Subject: RE: *EXTERNAL: [BDWS23254] RE: Felpham - FP/248/20/PL

- Drawing No. BDWS23254 11 **Rev. B** - Hard and Soft Landscape Proposals (Sheet 1).
- Drawing No. BDWS23254 11 **Rev. B** - Hard and Soft Landscape Proposals (Sheet 2).

Please find attached revised **Hard and Soft Landscape Proposals (Sheets 1 and 2)** for planning application **FP/248/20/PL – Site 6, Felpham (Blake's Mead)**.

date: April 2021
scale: 1:250@A1
drawing no: BDWS23254 11 Sheet 2
drawn: JM checked: DKM

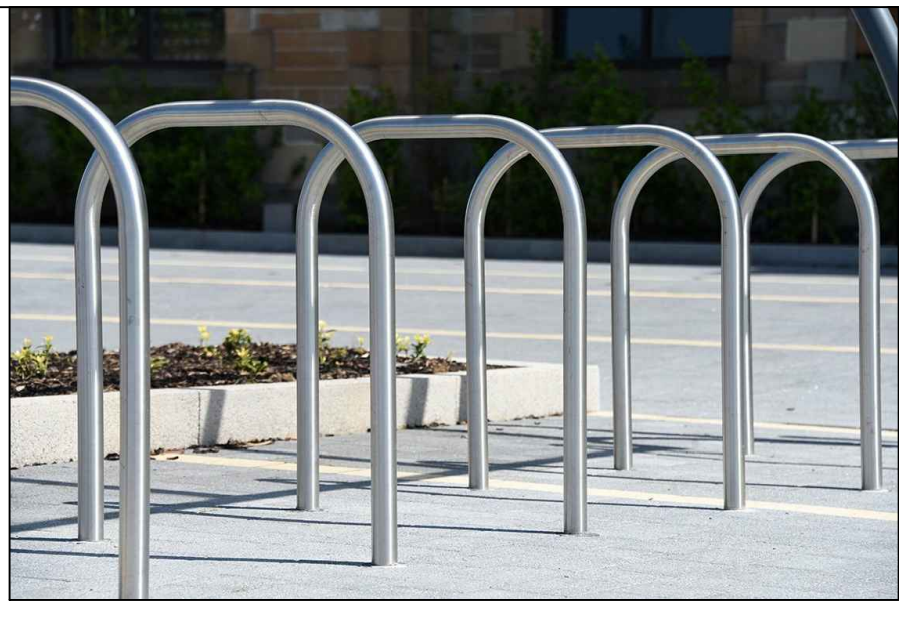
The fencing detail contained in the drawings ref below would appear suitable for location and application, specifically the knee rail, rebound and pond fencing.

The ball stop netting I am not familiar with as a product and I would recommend that further detail be provided (if not already) re posts, fixings, mesh type and perceived lifespan. I would also recommend that detail is submitted re maintenance requirements for this going forward, particularly in light that the LPA would be looking to take on the maintenance along with the sports facilities.
